Application for Removal or Variation of a Condition following Grant of Planning Permission or Listed Building Consent

Internal Alterations, Two Storey Side and Rear Extension Attic
Conversion including Dormer to Rear, and Rendering of First
Floor Front Elevation

23/00450/FHA

Change in materials new drawings below -
22011 AL (0) 110D
22011 AL (0) 111D
22011 AL (0) 120D

[NUMBER] 22011 AL (0) 110D

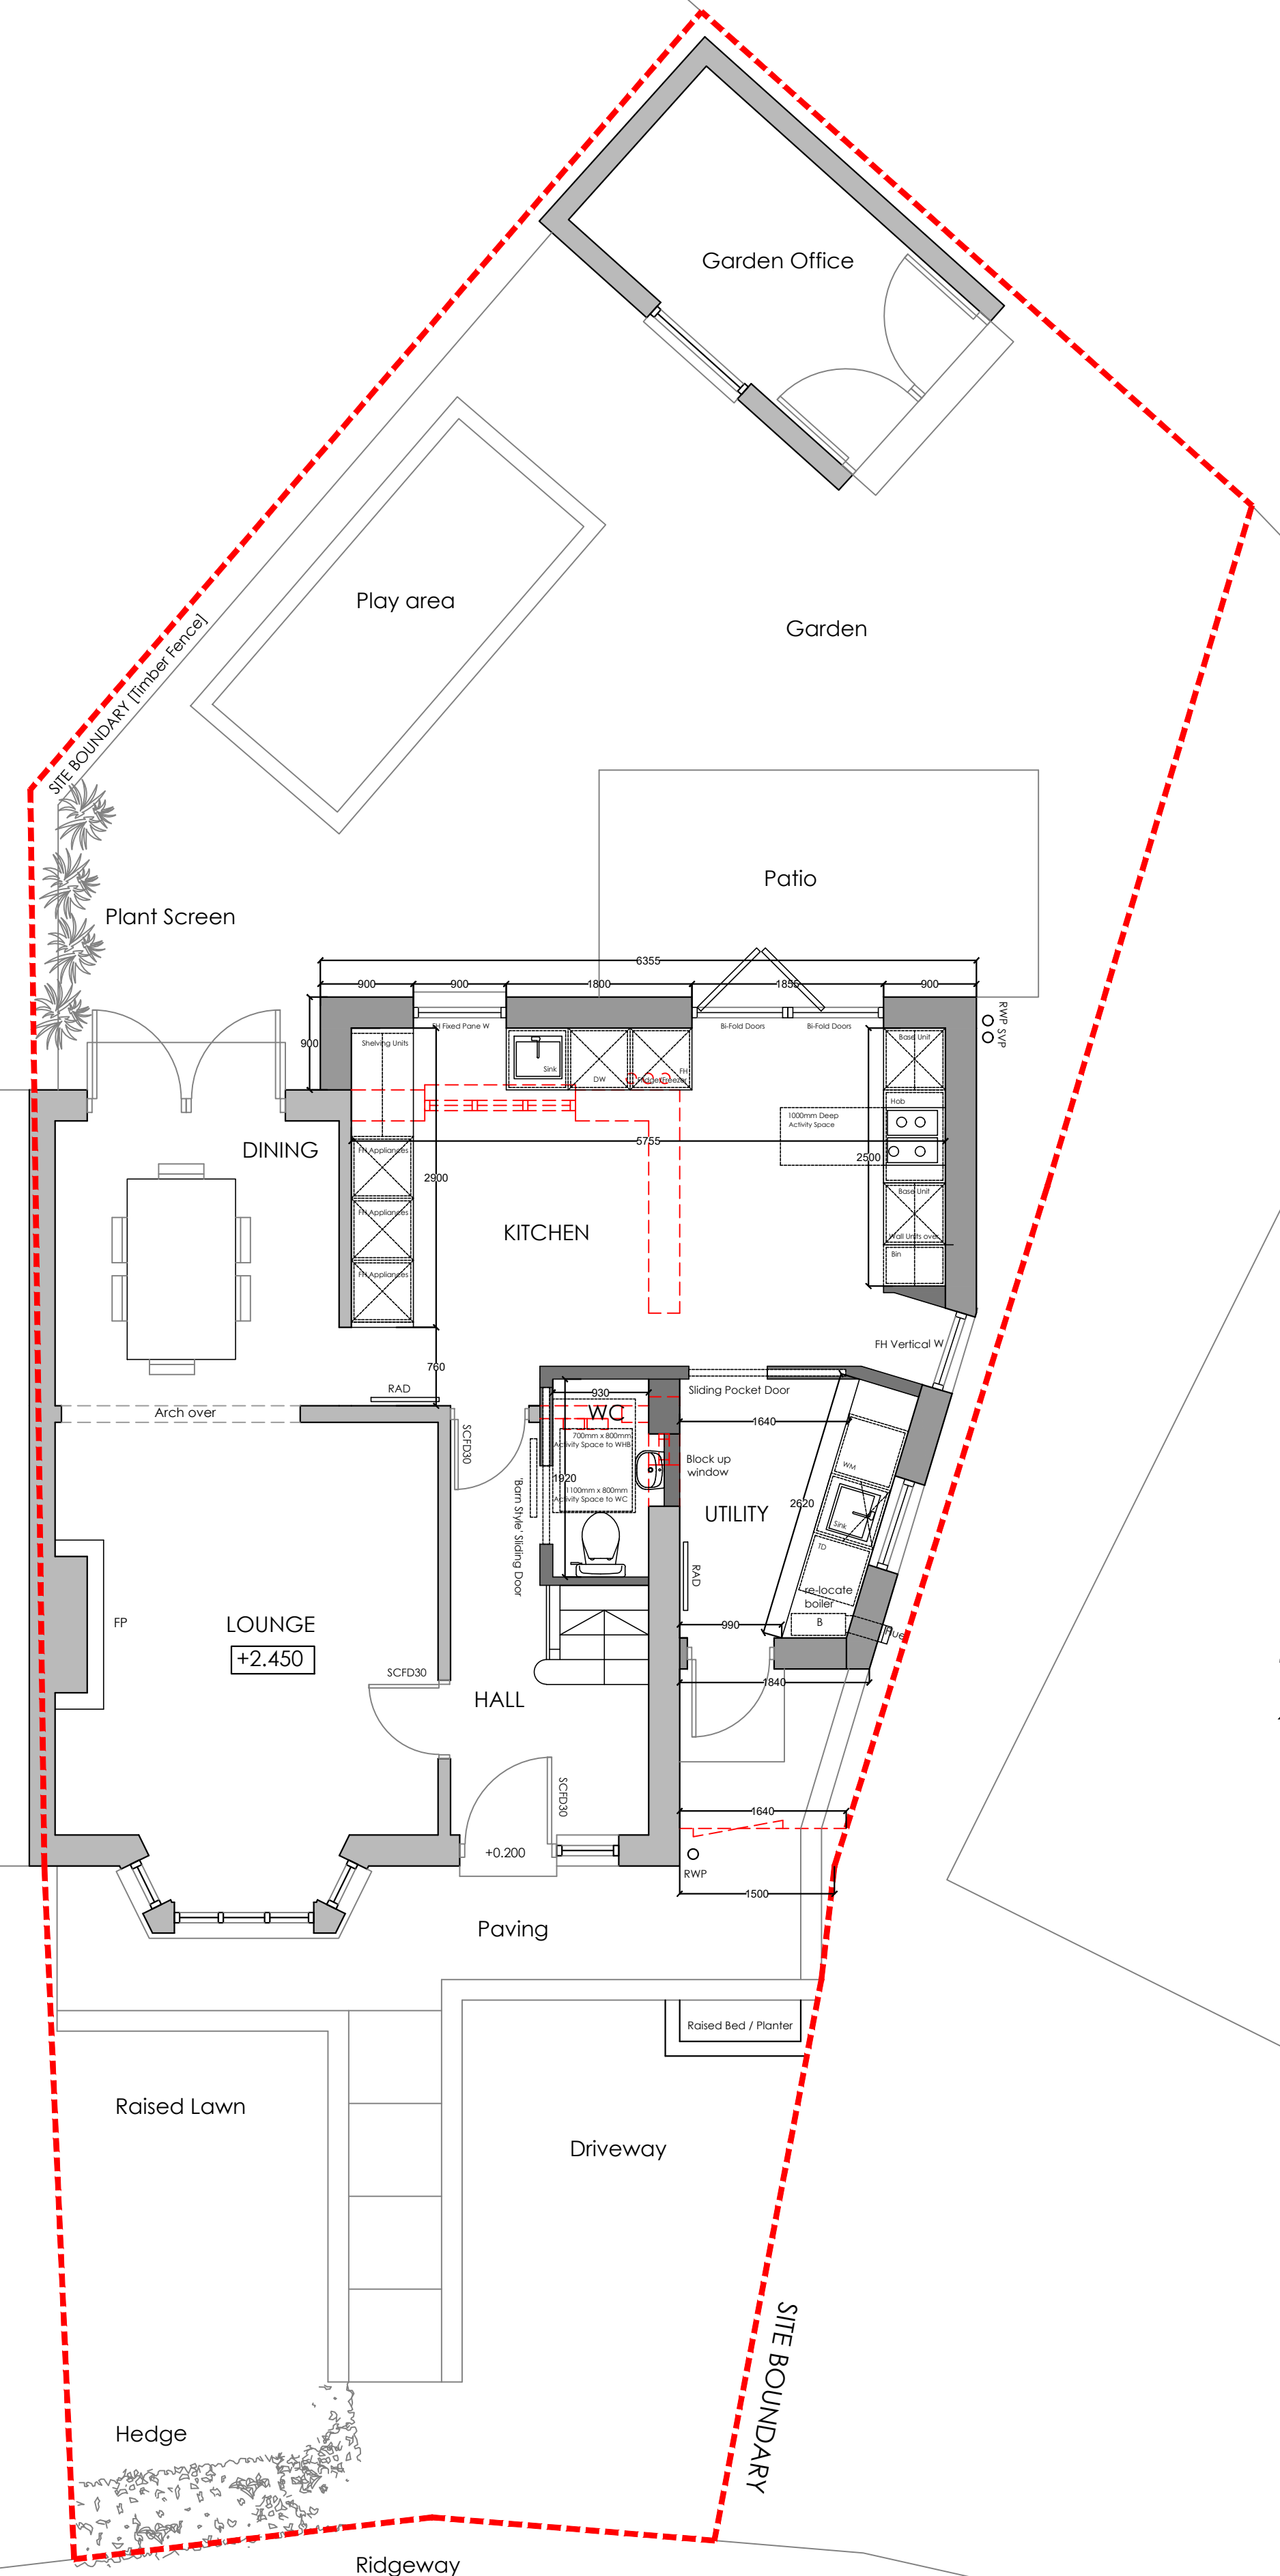
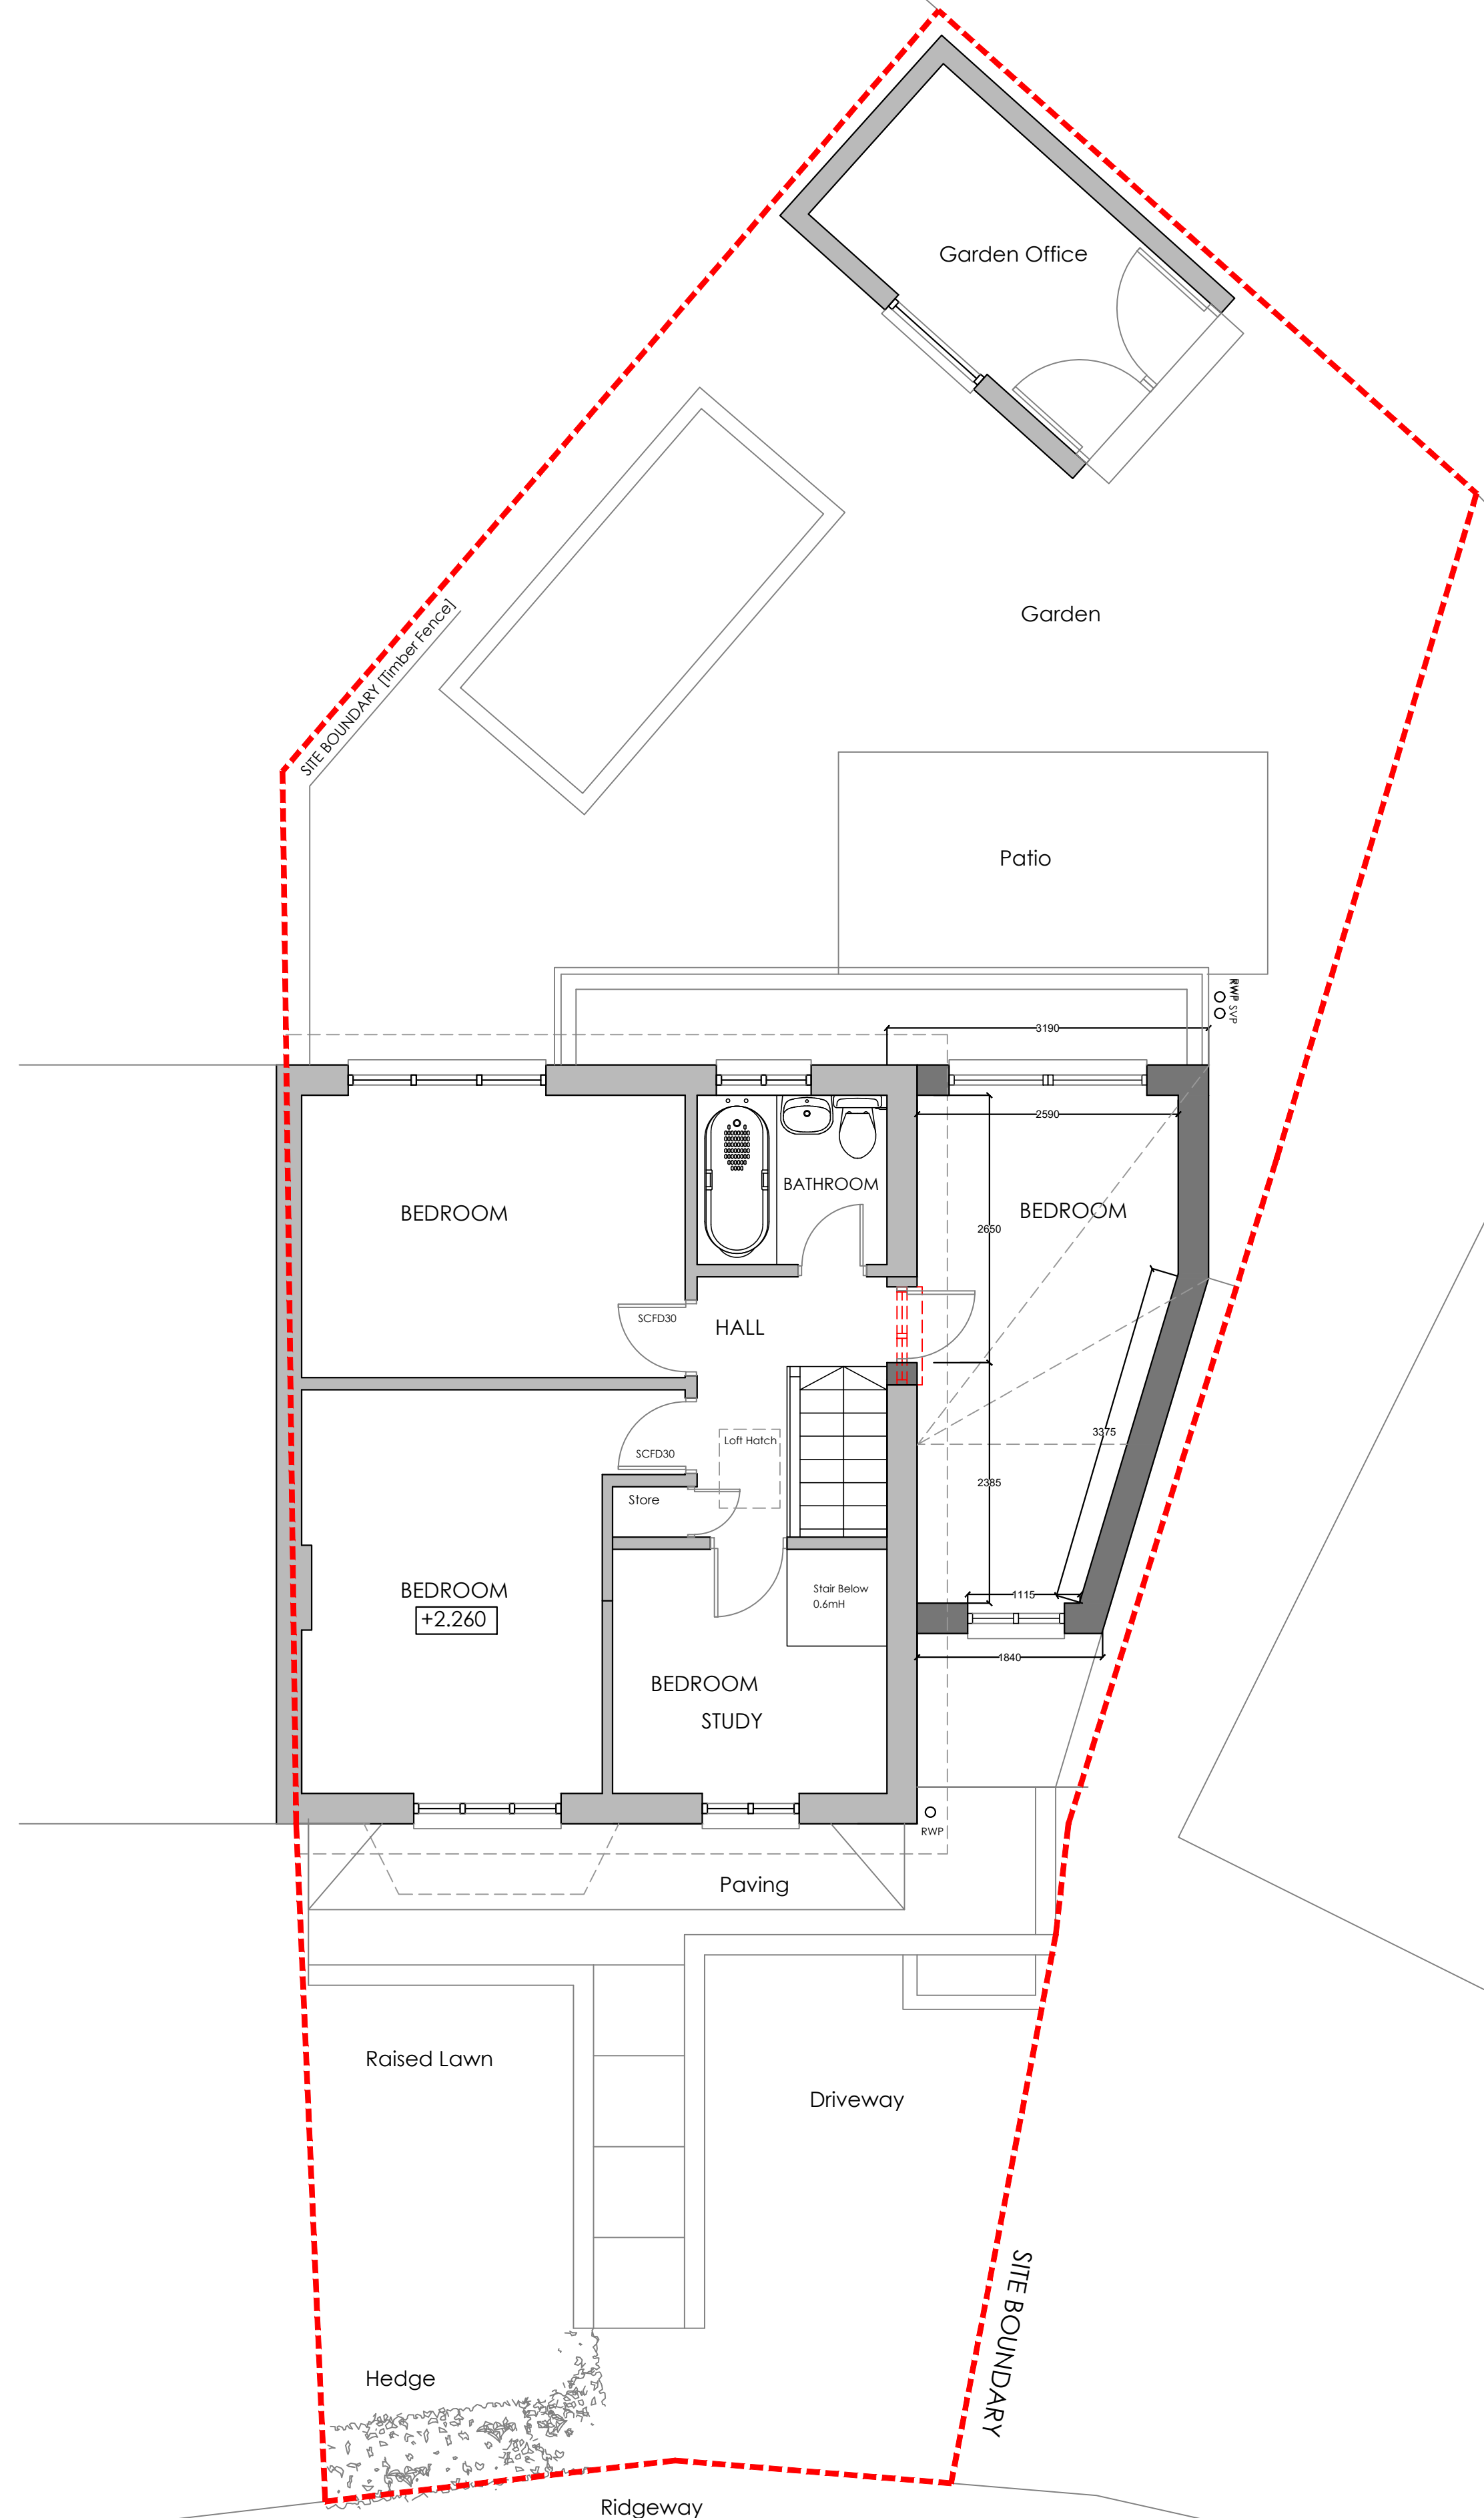
Change in Materials - omit proposed render to front / rear elevations
Omit Loft Conversion works
Omit Rear Dormer Window
Omit Velux Windows
